Re: Fortuna Coffee Shop TIA City of Albuquerque & NMDOT Comments

The following documents comments received from CABQ & NMDOT and responses for the Fortuna Coffee Shop TIA.

TRAFFIC
CIRCULATION
LAYOUT -
PROPOSED

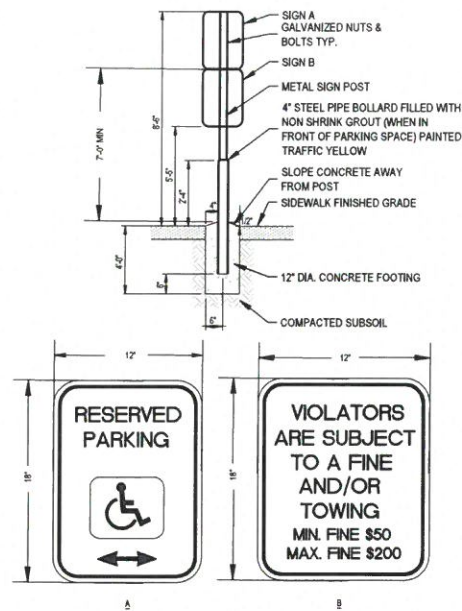
Comment 1 - Provide evidence of an transportation easement between the property being developed and the property that borders it to the north (700 Coors Rd. and 730 Coors Rd.). This is needed if you intend to build the proposed cross-access drive shown in Figure 1, Site Plan.

Comment 2 - Shared access agreement for the driveway connection to Coors Blvd from the parking lot at address 730 Coors Rd. NW as shown in Figure 5, called "Coors Blvd. Driveway". We need to know that this will be allowed by your neighbor.

Response 1: Accepted. These items have been added to the Appendix.

Response 2: Accepted. These items have been added to the Appendix.
